Our Ref: BE/38/19/PL
Your Ref:

Town & Country Planning Act 1990 (as amended)
Town and Country Planning (Development Management Procedure) (England) Order 2015
Application for Planning Permission

Development Creation of temporary soil storage bund associated with development of adjoining site at Saltbox

Location Adjoining site at 10 Acre Field west of Saltbox Rowan Way Bognor Regis

TOP SOIL RELOCATION
LOCATION PLAN
1744-TS-P01-A

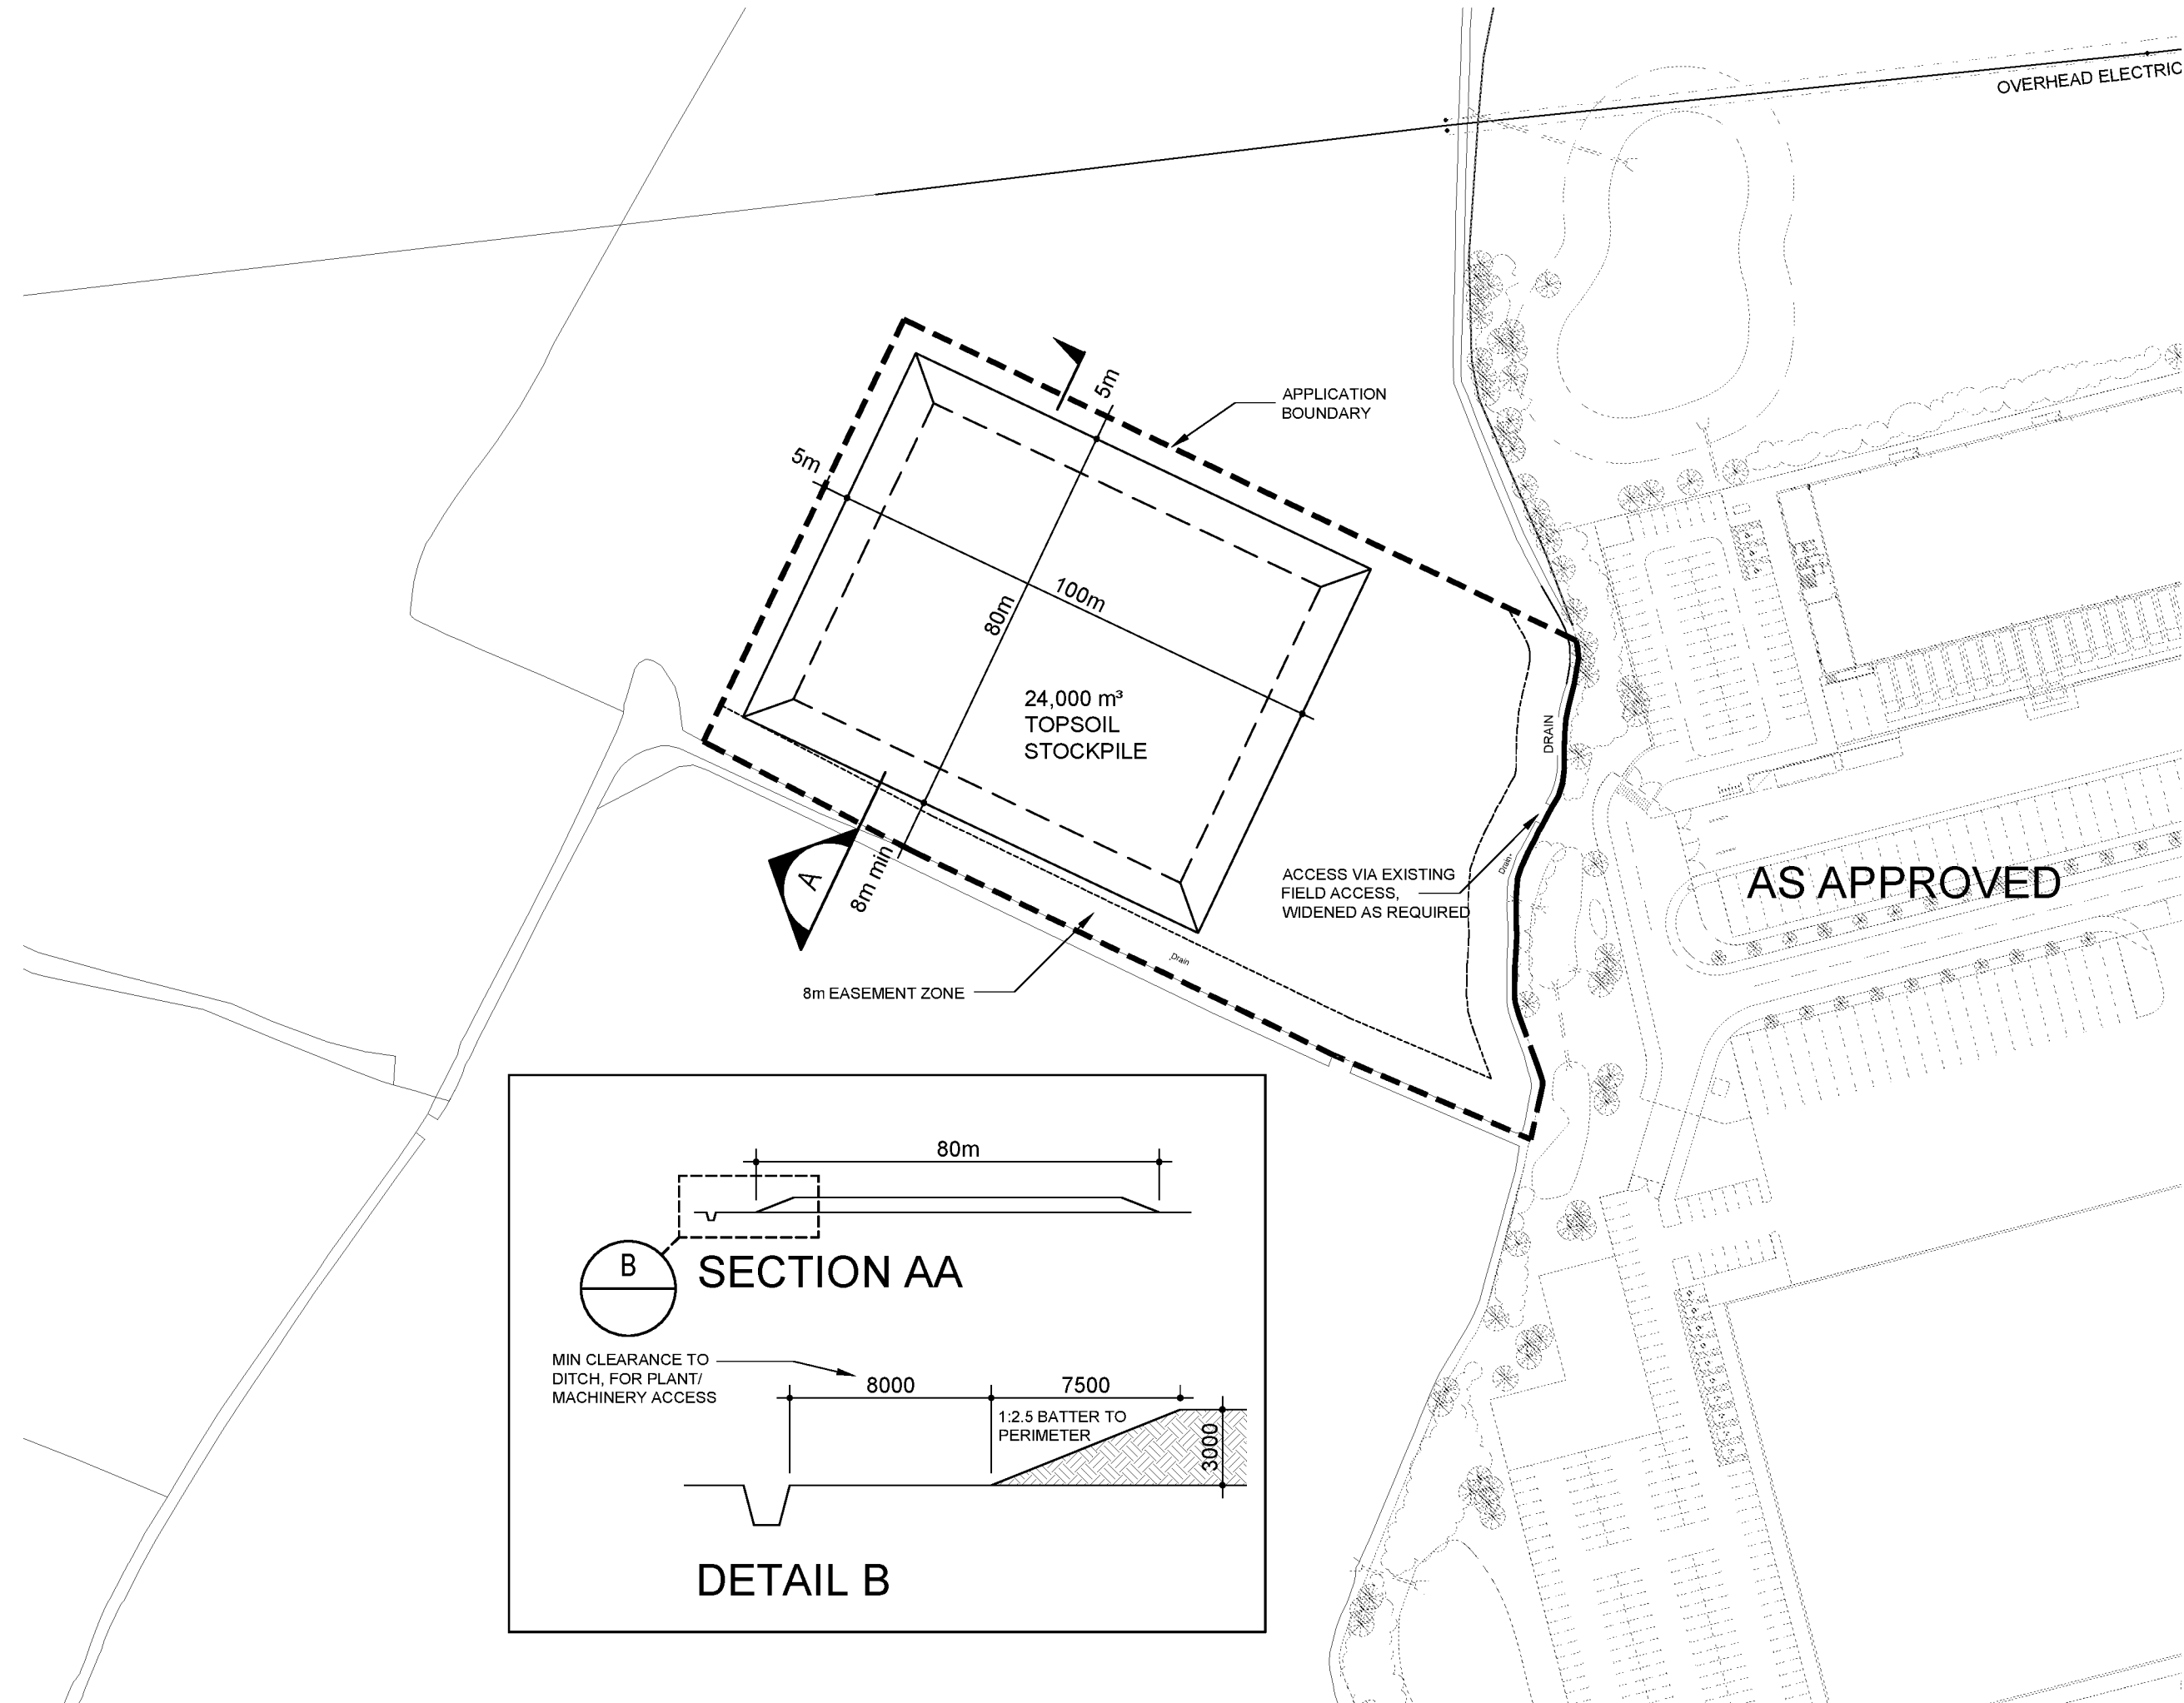
Location Plan Amend

Please provide two named roads.
